**Consultation Response from KC,
Trees**

2023/91337 Acre House, Acre Street, Lindley, Huddersfield, HD3 3EA

Erection of 4 detached dwellings (within curtilage of a Listed Building)

Location Plan

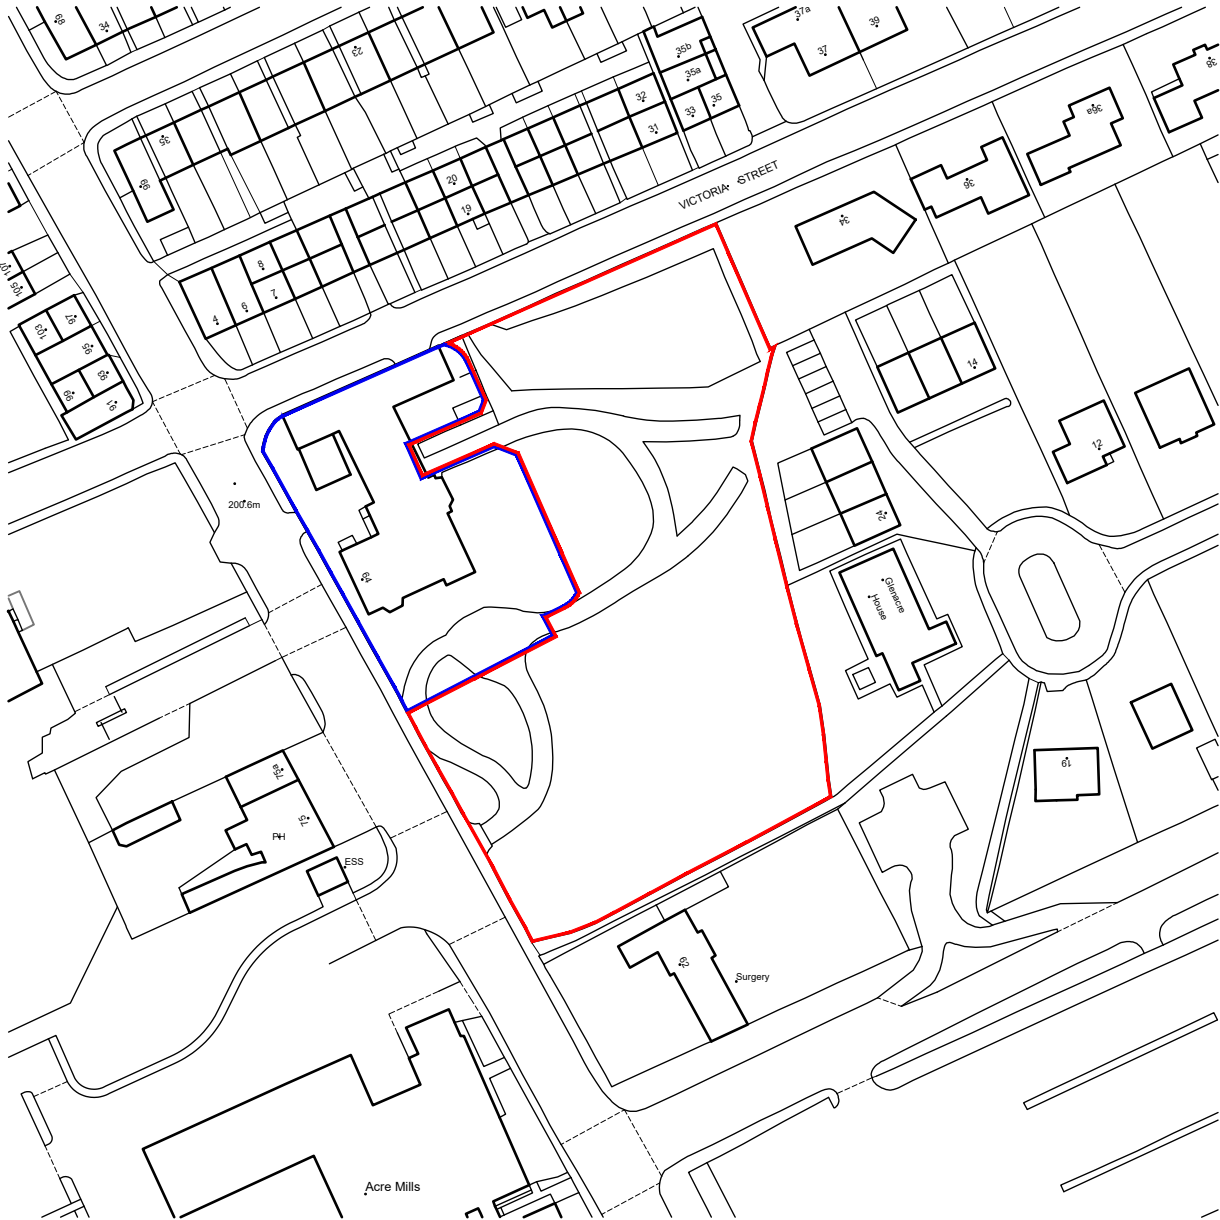
My only concern is that the garden and rear elevation of plot 2 will be shaded by the existing trees. I would like to see the proposed dwelling moved further north, with no dig construction used for the driveway within the RPA's of trees T4 to T7. Moving the dwelling forward will also provide greater space between the proposed dwelling at the canopies of T1 and T2.
